WEST SUSSEX COUNTY COUNCIL CONSULTATION

TO:	Arun District Council FAO: Anita Gardner
FROM:	Stephen Gee Highways, WSCC
DATE:	12/02/2019
LOCATION:	Land East of, Fontwell Avenue, Fontwell, West Sussex
SUBJECT:	WA/1/19/PL Variation of condition 24 following the grant of WA/22/15/OUT (APP/C3810/V/16/3143095) to read 'No more than 150 units hereby permitted shall be occupied for more than two years lapse from the date of first occupation of the development (whichever is sooner) until the completion of the improvements to the A/27/A29 Fontwell Roundabout shown on Drawing Number 1186-05 REV A - Proposed Roundabout Improvements'. This application also lies within the parish of Eastergate.
DATE OF SITE VISIT:	11/02/2019
RECOMMENDATION:	☐ Advice ☐ Objection ☐ Modification ☒ No Objection ☐ More Information ☐ Refusal
S106 CONTRIBUTION TOTAL:	£ See below for breakdown.

Figure 3-1: VISSIM Journey Time Paths

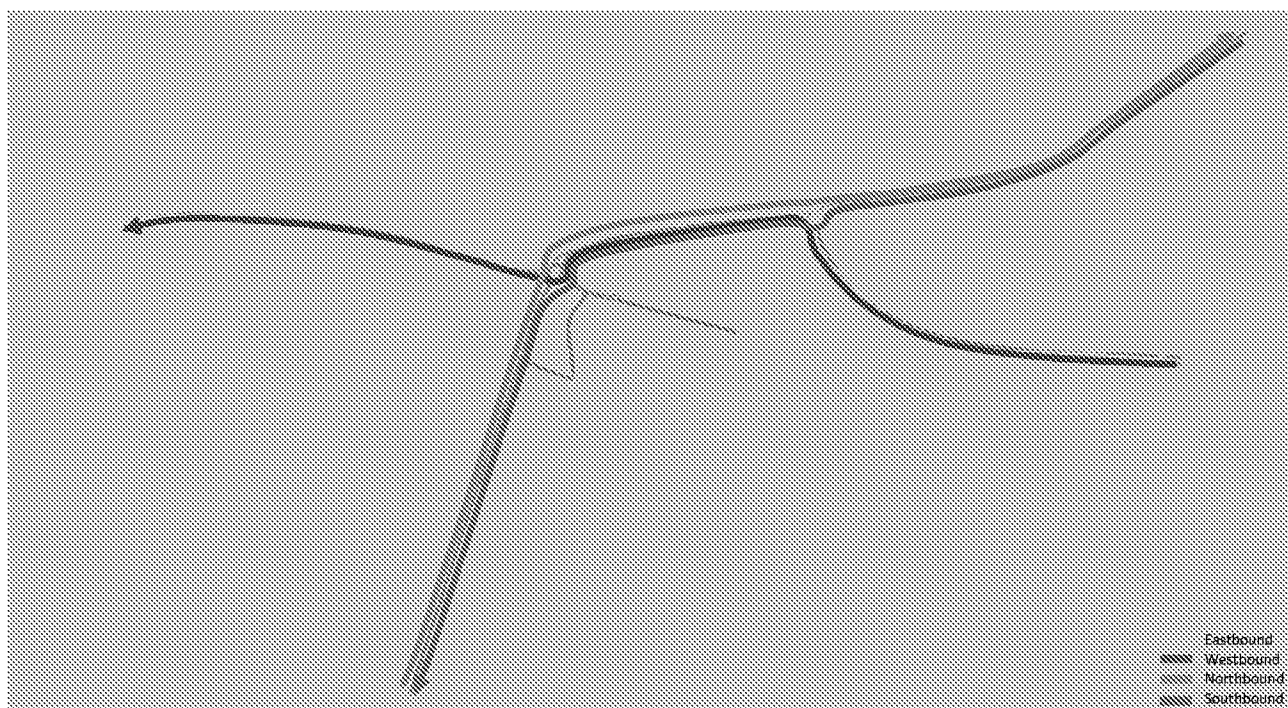
In the AM peak, northbound journey times would increase by 26 seconds over an route much wider than just the junction (as shown in figure 3.1) and in the PM peak a maximum increase of 4 seconds.
